CITY OF ALBUQUERQUE

February 9, 2024

**RE: Rio Grande Apartments
2211 Rio Grande Blvd. NW
Grading and Drainage Plans
Engineer's Stamp Date: 01/22/24
Hydrology File: H12D024**

MILLER ENGINEERING CONSULTANTS
Engineers • Planners
3500 COMANCHE, NE
BUILDING F
ALBUQUERQUE, NM 87107
(505) 888-7500
(505) 888-3800 (FAX)

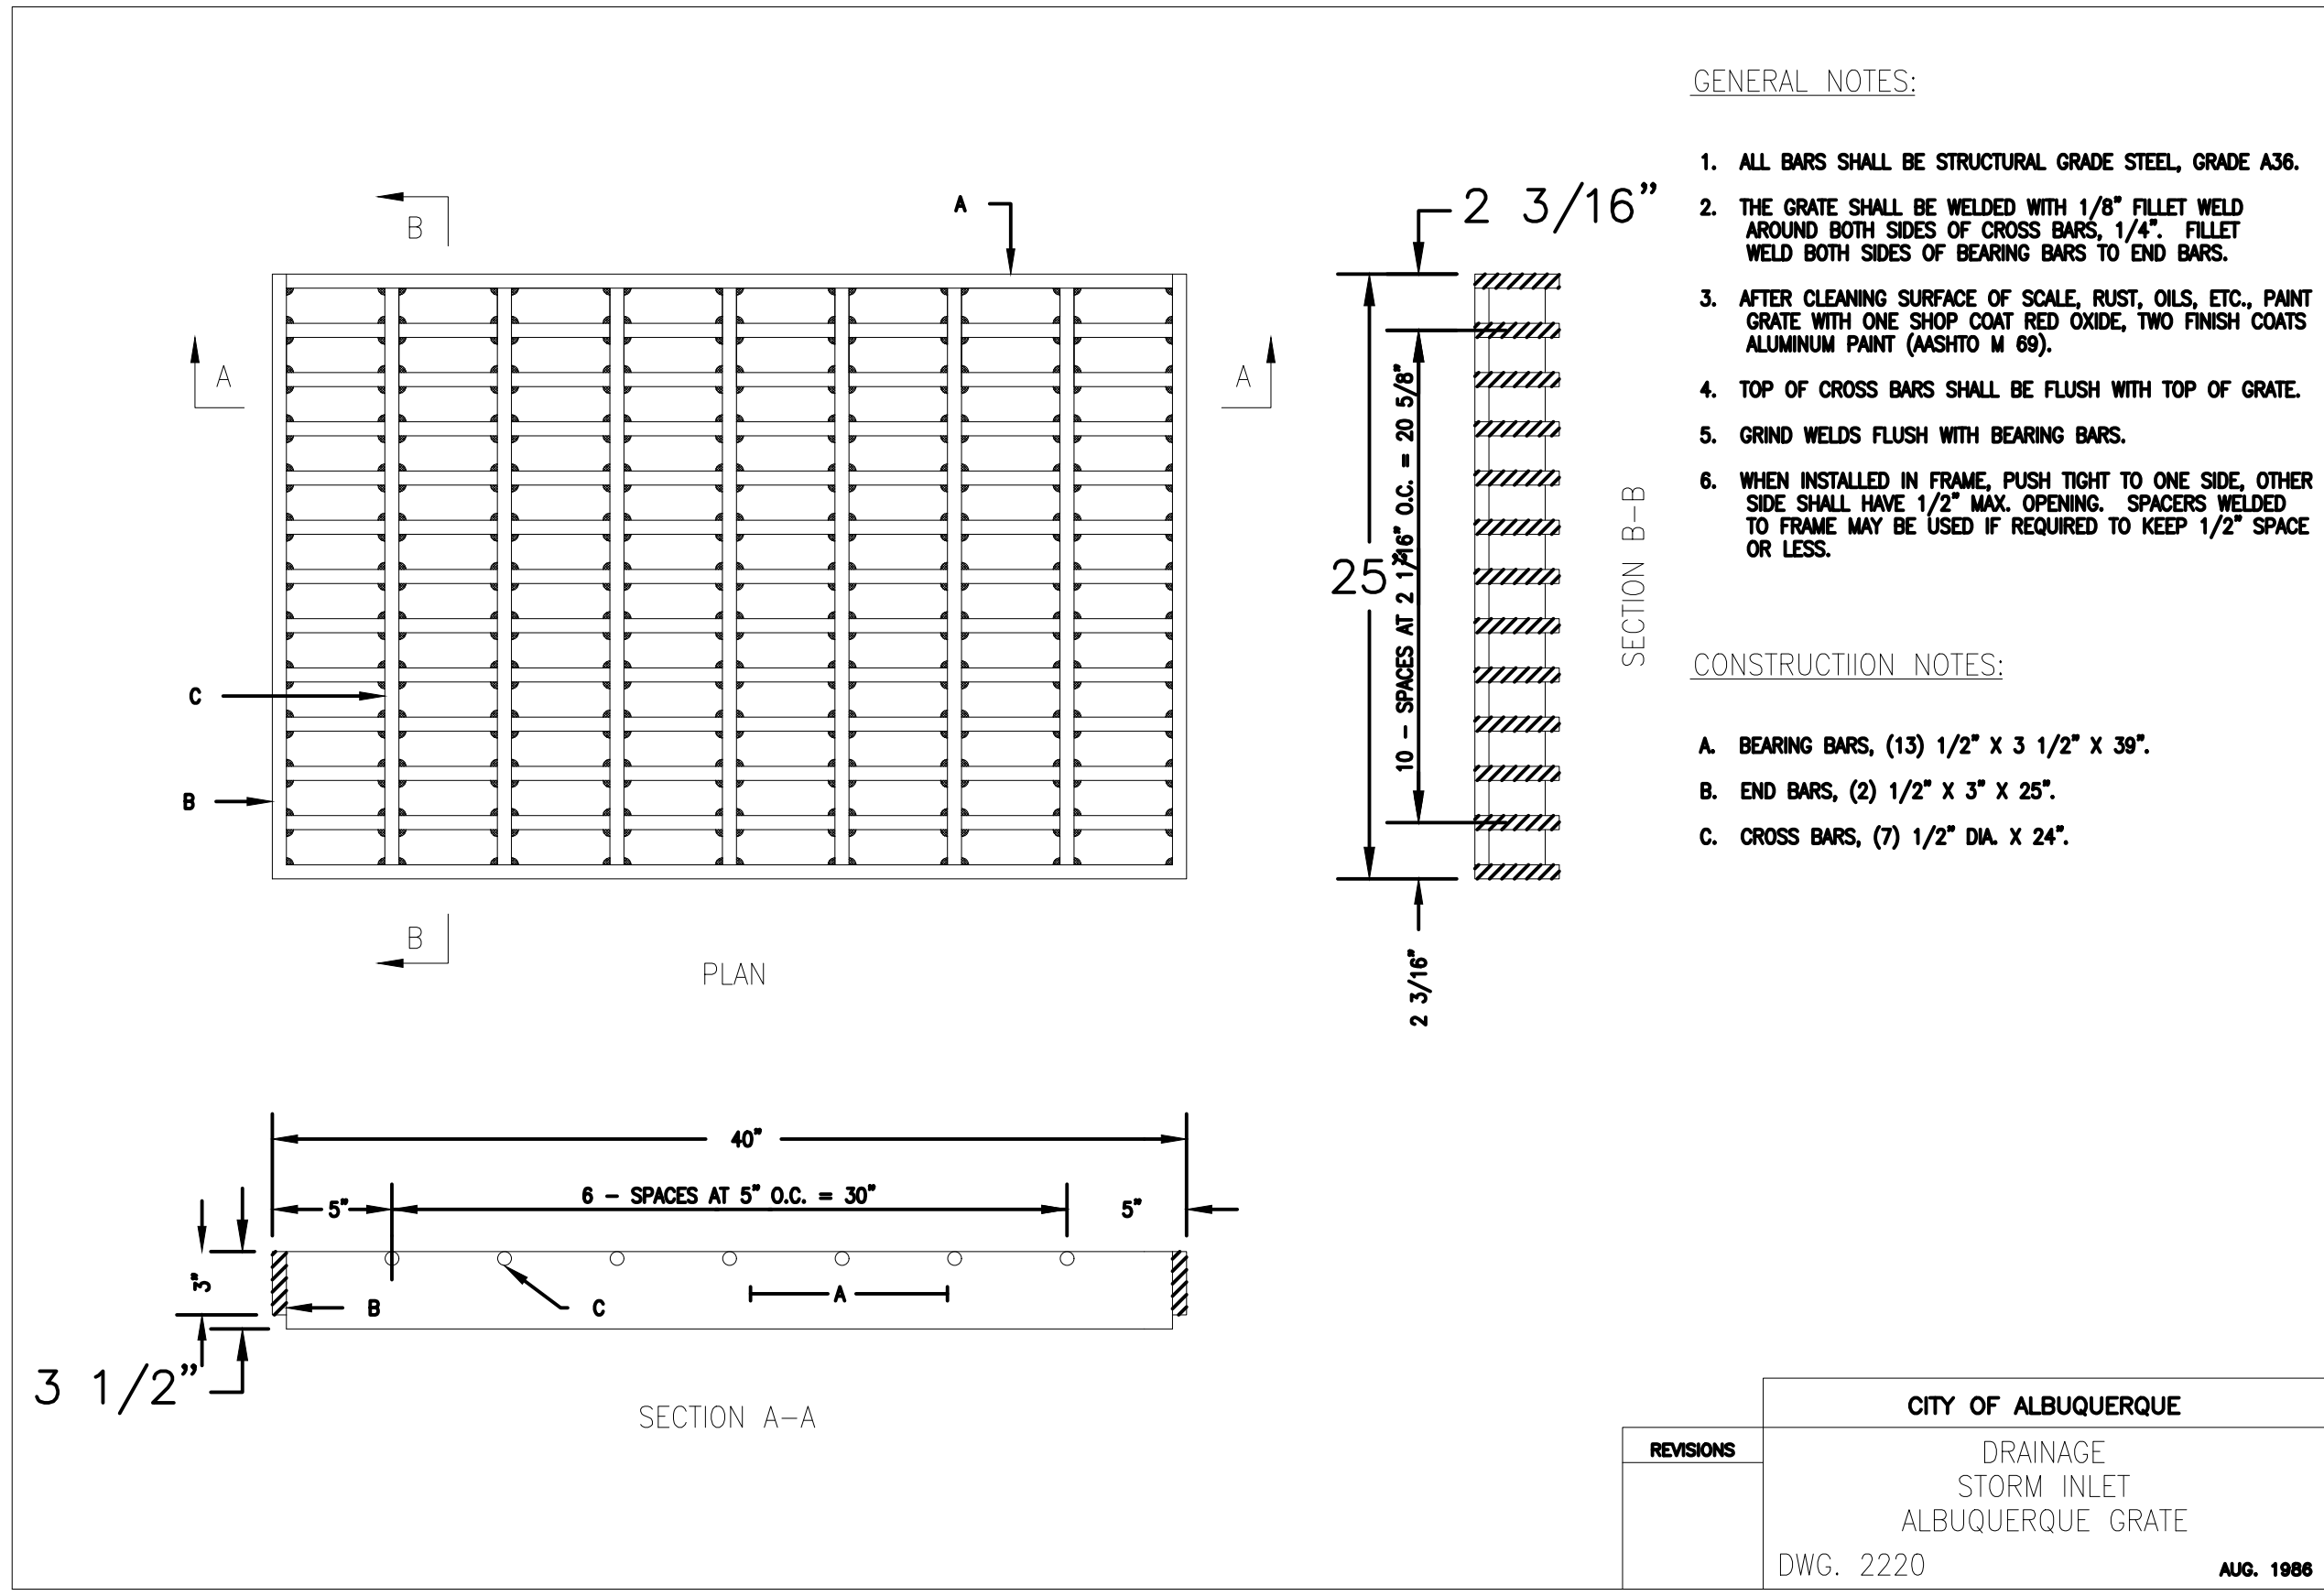
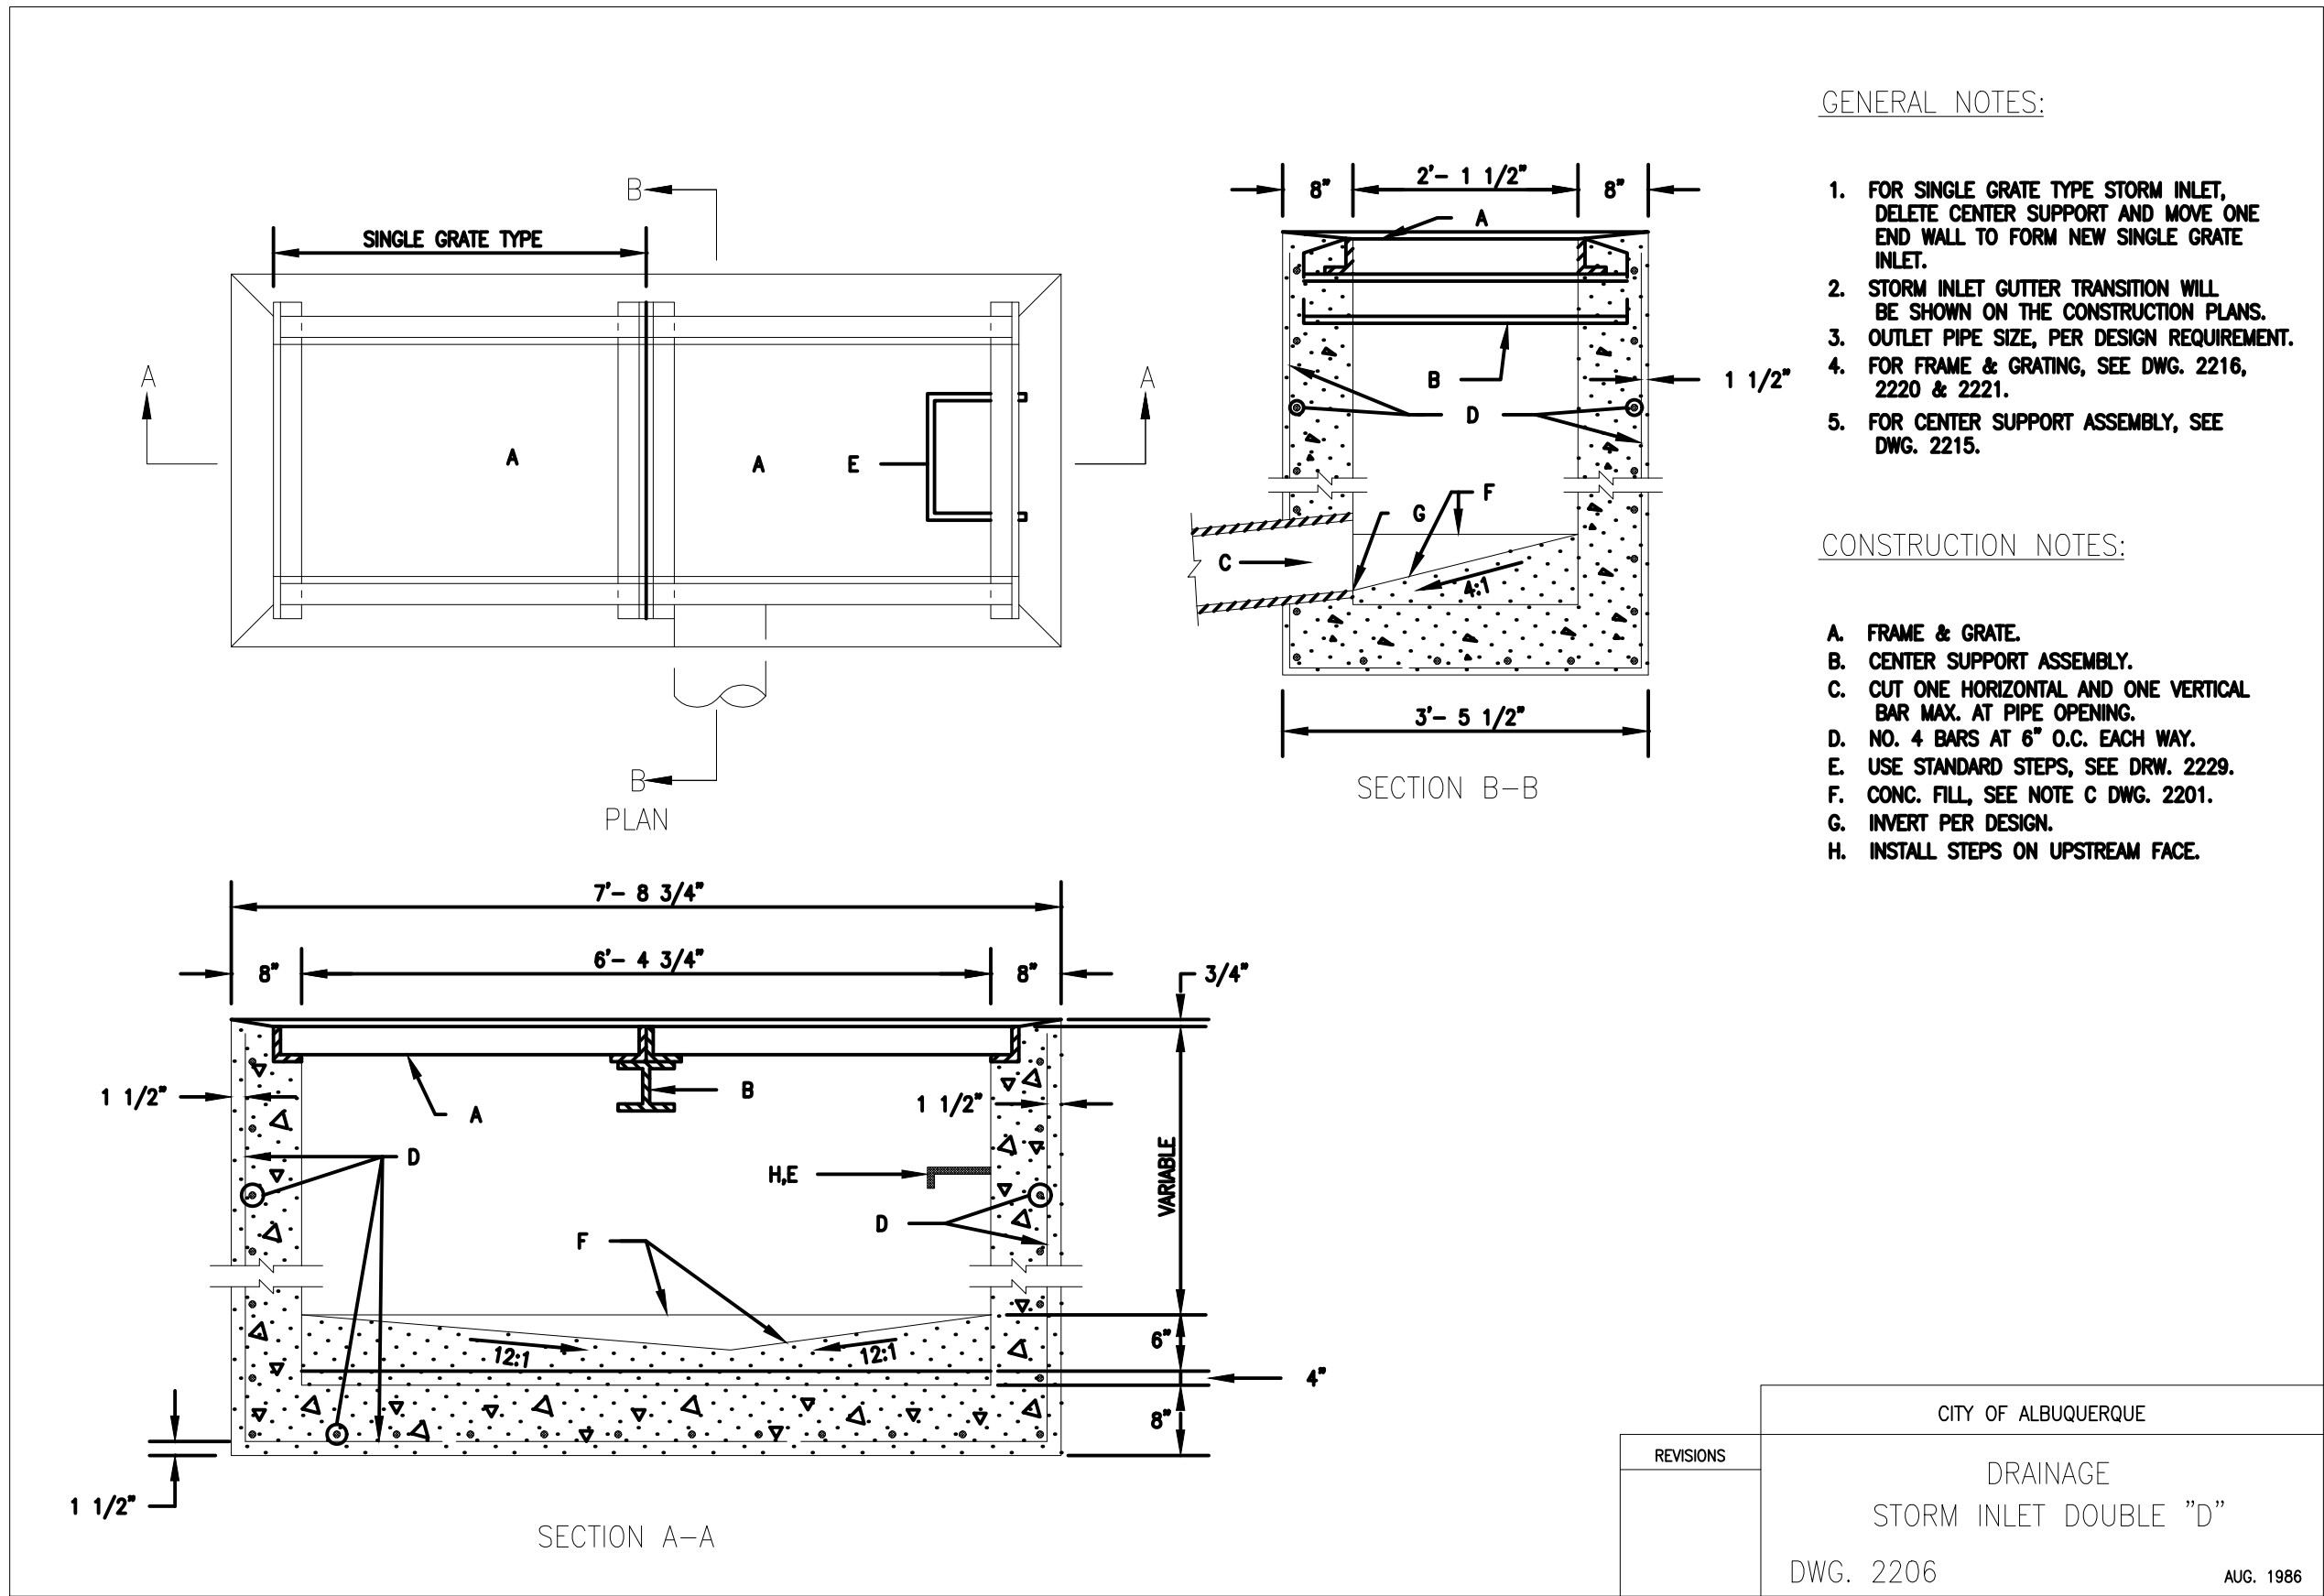
SHEET C-501

14. In the cross section, please showing property/ROW lines and add a note stating that the contractor shall waterproof the proposed retaining wall below the 100-yr 10 day water surface elevation of XXX per City standards. In accordance with DPM, grading and wall construction near the property line may not endanger adjacent property or constrain its use. Please make sure that the footer for the wall stays within the project's property. Also move this onto the Grading Plan per Comment #10.

15. The remainder of the details on this sheet or either just standard City details, which don't need to be shown. Just call them out on the Grading Plan as per COA Standard Drawing XXXX.
